Submission Form

Epping to Thornleigh Third Track Proposal. Application number SSI 5132.

Name(s): Gregory + Sarah Cook

Figure S.6 Cross-section and elevation - New Cheltenham Station concourse building (see also S.5 for artist's impression)

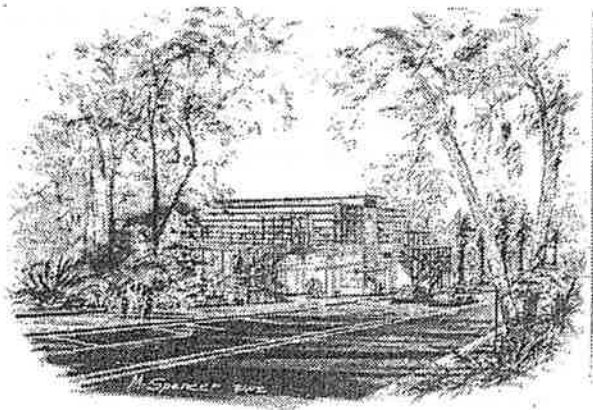
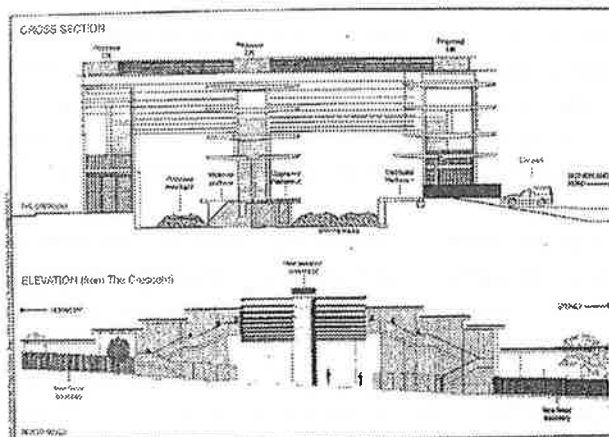
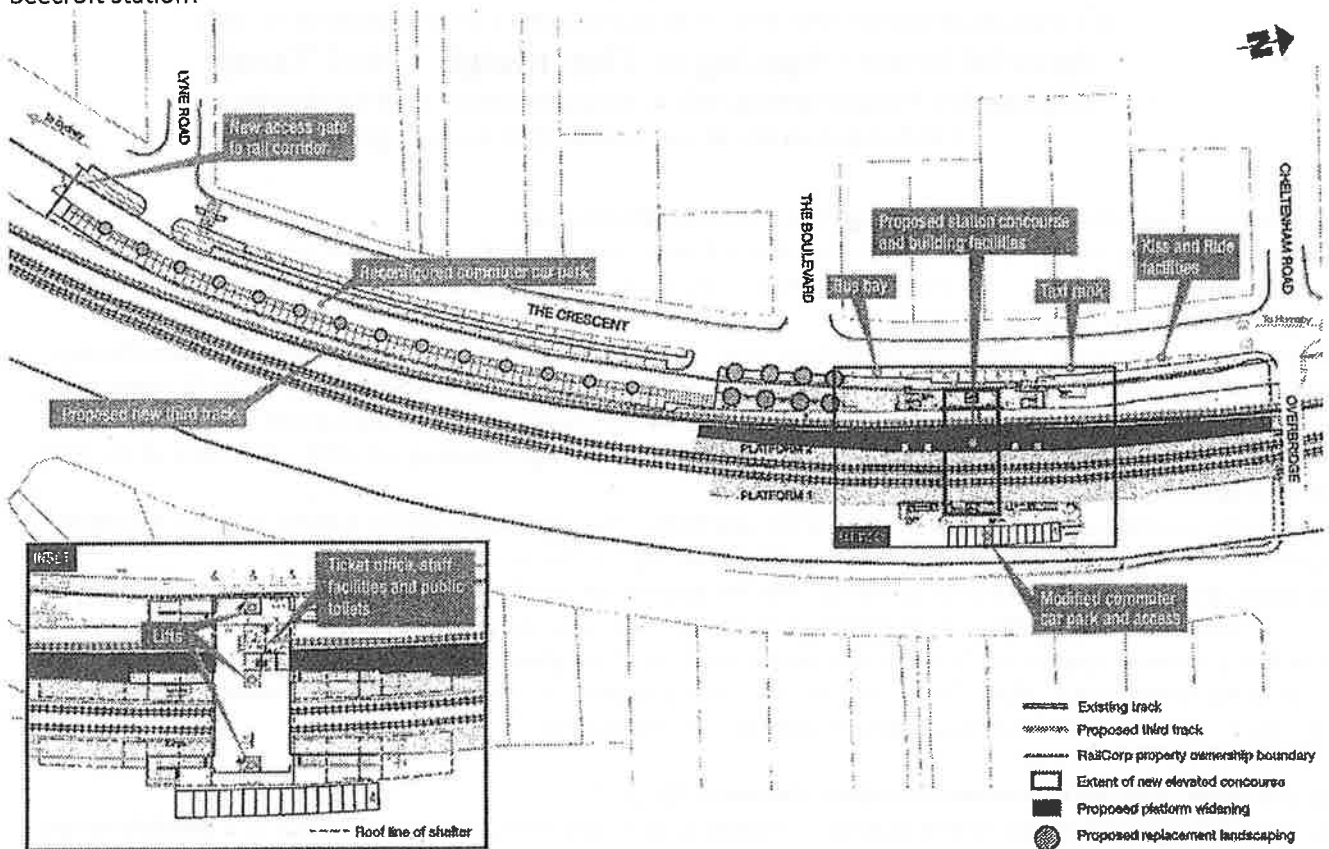
- The proposed redevelopment of Cheltenham Station shows no regard for the HCA. The visual impact of the proposed 13m high glass and steel concourse is totally unacceptable in this HCA.
